2024/0991

2 Wareham Grove, Dodworth, Barnsley, S75 3LU

Erection of single storey side extension, conversion of existing garage to office, new wall and establishment of two parking spaces

PROPOSED WALL
SCALE 1:100

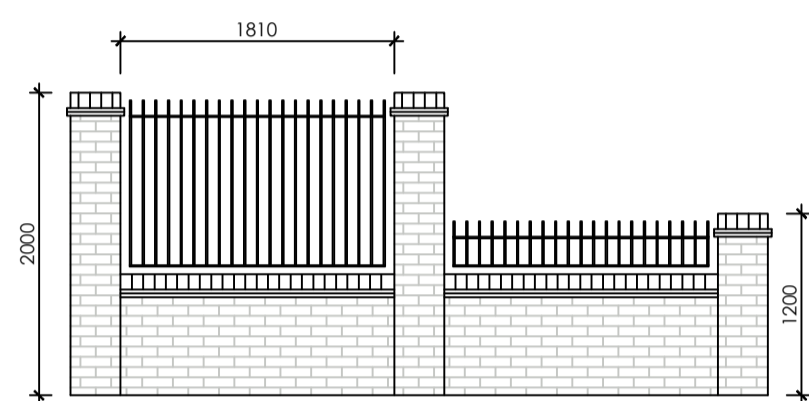
The proposed 2-metre-high wall is proposed to be constructed from similar materials to the existing wall along with a similar design. Pillars along with inserts are proposed. This design is considered acceptable as it matches the existing 2 metres high wall. The 1.2-metre-high wall is considered acceptable as it provides a similar design to the existing 2-metre-high wall however at a reduced level. The proposed fence to the east of the site is a similar style to existing fences adjacent to the site and will be in keeping with the character of the street scene. This weighs significantly in the proposals favour.

PROPOSED GROUND FLOOR PLAN
SCALE 1:50

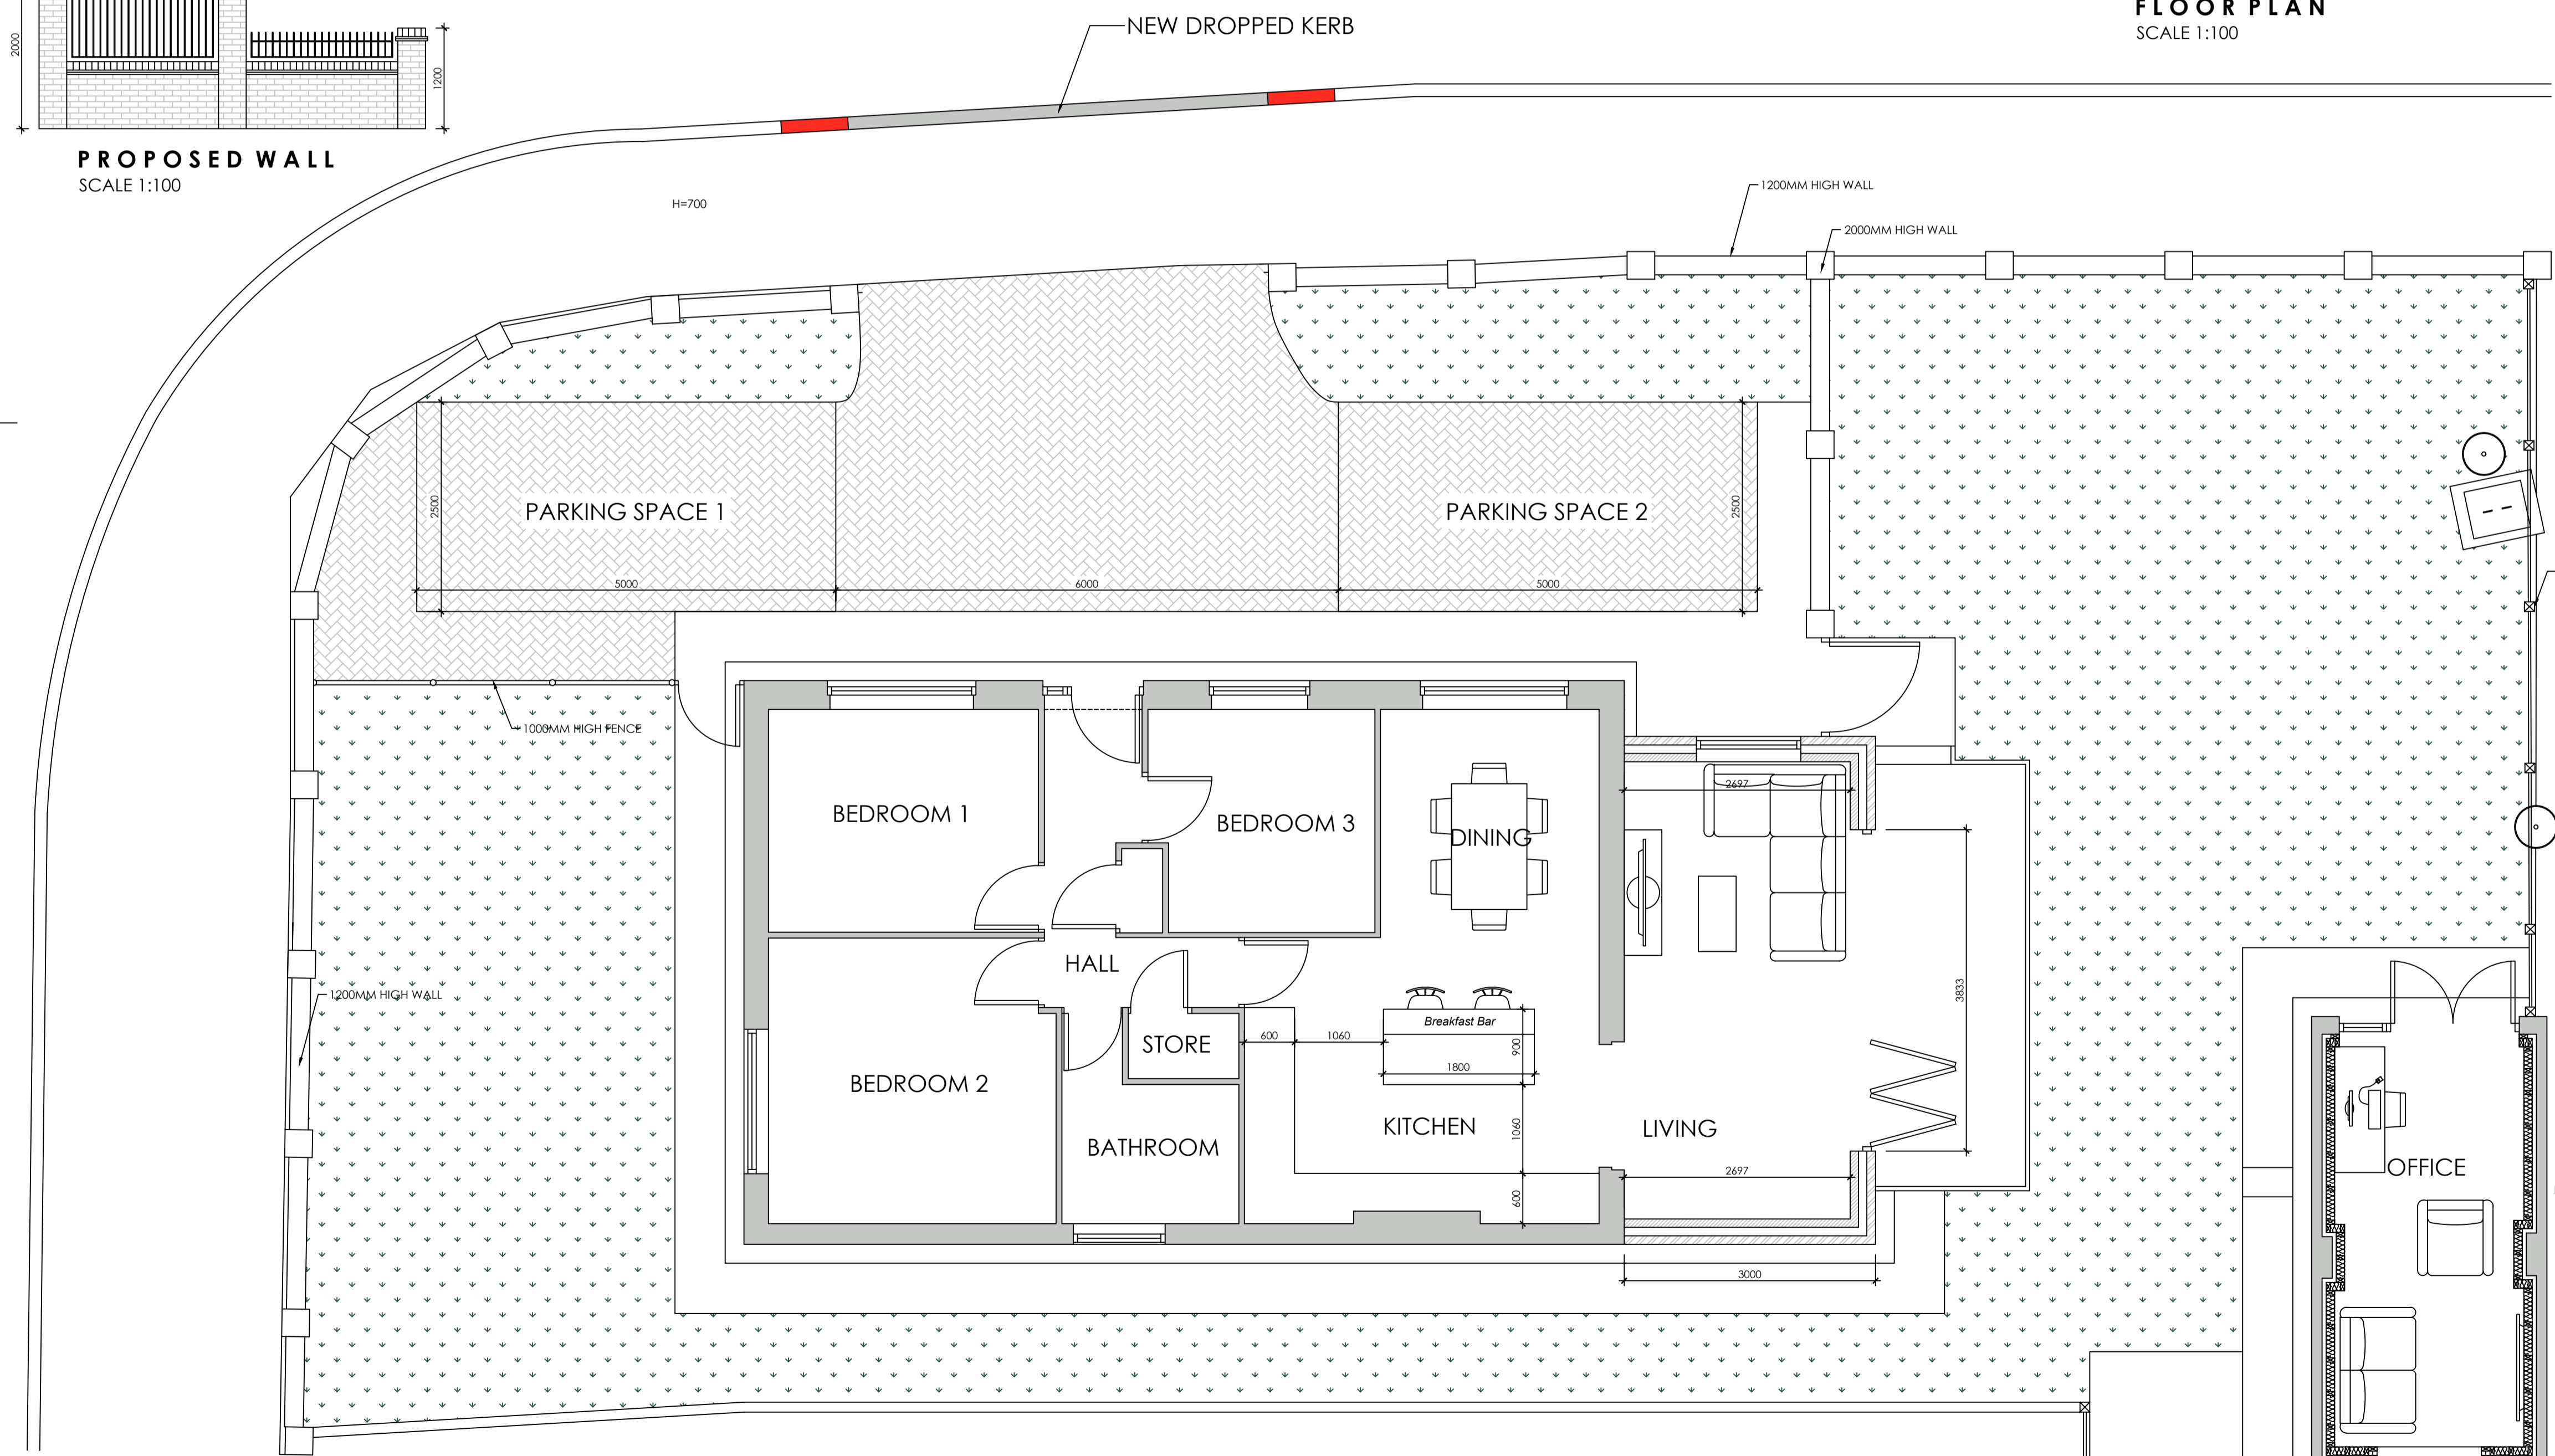
The proposed side extension would have a sideways projection of approximately 3 metres with a length of approximately 6 metres. A flat roof is proposed with an approximate height of 3.1 metres. Bifold doors are detailed to the southeast elevation of the proposal spanning approximately 3.8 metres. A window is detailed to the northeast elevation of the proposal. The proposal is detailed to function as living room. Matching brickwork is detailed.

The proposed side extension provides a moderate sideways projection of approximately 3 metres. The site does not provide the largest of gardens, however given the proposal is to encompass the previously used drive, the proposal provides an extension less than half the size of the existing garden space. The use of a flat roof is not preferred. A roof form similar to the existing dwelling would have been preferred however, given the extension could be erected under permitted development (not requiring planning permission) the roof form is considered acceptable. This weighs moderately in the proposals favour.

The property accommodates 3 bedrooms and currently provides the required 2 parking spaces for a 3-bedroom dwelling. Although the proposal removes the garage and parking facility, this has been relocated within the site to provide 2 parking spaces to the front of the dwelling. The provided parking facility is therefore considered acceptable. Although the proposed dropped kerb is within the standard 20 metres separation distance between the access and a junction, given the residential nature of the area and similar arrangements with the site area this is considered acceptable. Although the proposed 1.2 metre wall exceeds the desired 0.6 metre height, the 4.9 metre width of the entrance provides adequate pedestrian visibility splays. The 2 metre high section of the wall does not impact on vehicular or pedestrian visibility. As such, this weighs considerably in the proposals favour.
